Kevin Cox
Crime Prevention Design Advisor
Thames Valley Police Headquarters South
Oxford Road
Kidlington
Oxfordshire
OX5 2NX

REF: 23/00517/F

**Location: New Science Park Land West Of The Junction
With The Boulevard Oxford Airport Langford Lane
Kidlington**

27 March 2023

Typical Cycle & Bin Store - Plan
1:100

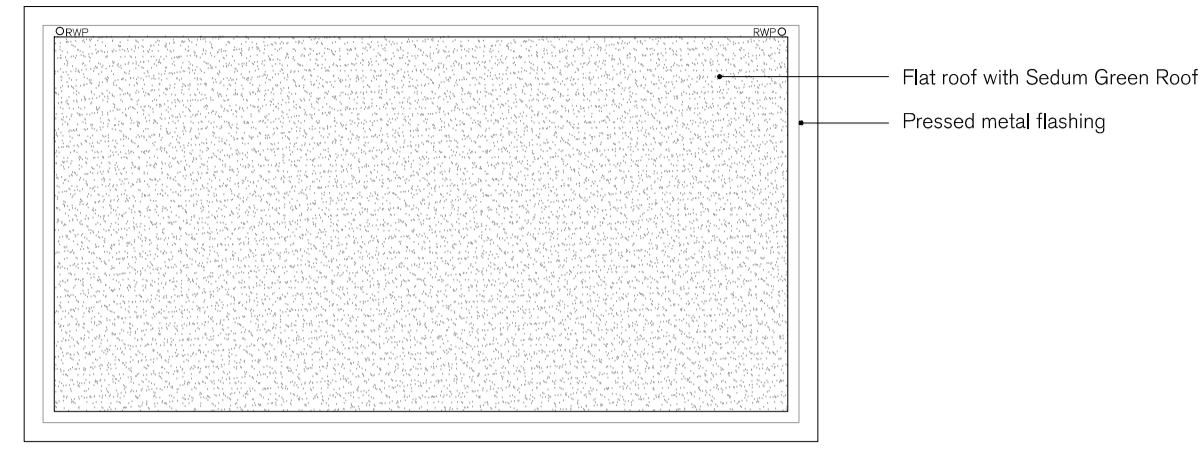
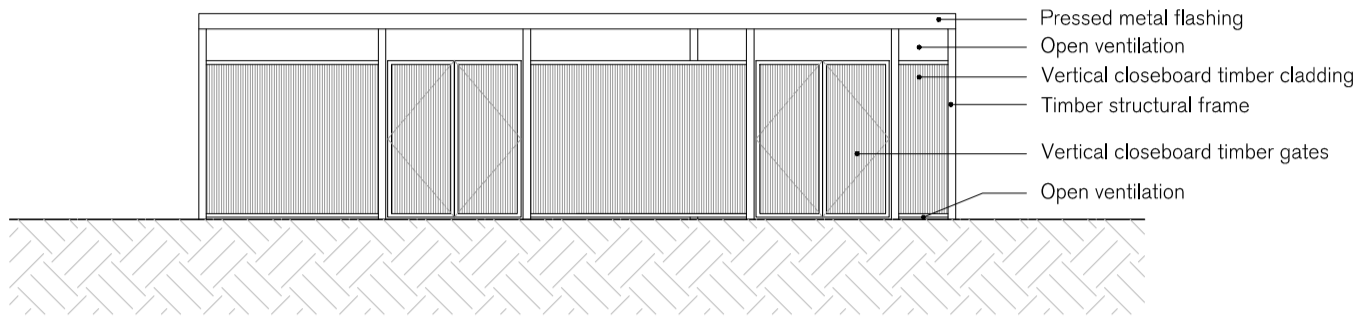
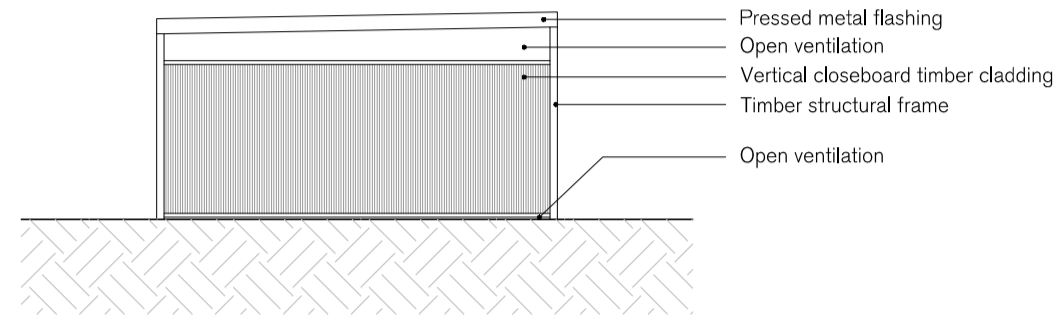
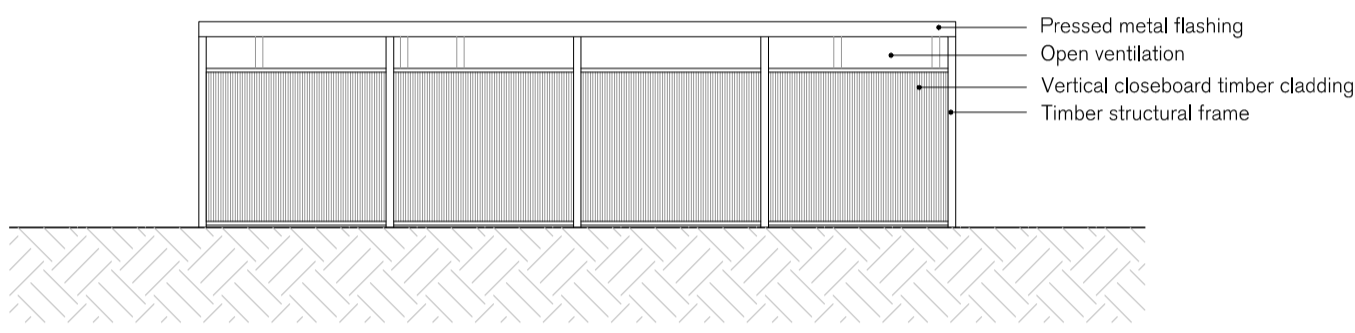
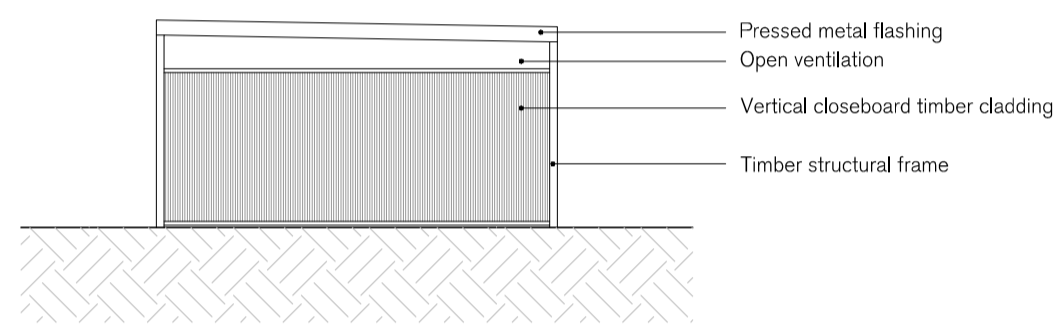
Due to the remote location cycle stores away from buildings, it is imperative that they are robustly secured to prevent unauthorised access. External cycle stores must be locked and access controlled, well lit at night, and covered by CCTV. Cycle stores must contain storage devices certified to one of the following standards;

Bin stores should also be robustly secured, access controlled and covered by CCTV. I note within the DAS that it is proposed that bins will be left out for collection, however this creates a risk that bins may be a target for crime such as arson. I recommend bins are kept secure at all times, with management practises in place to facilitate collections and reduce the time they are left insecure to the absolute minimum.
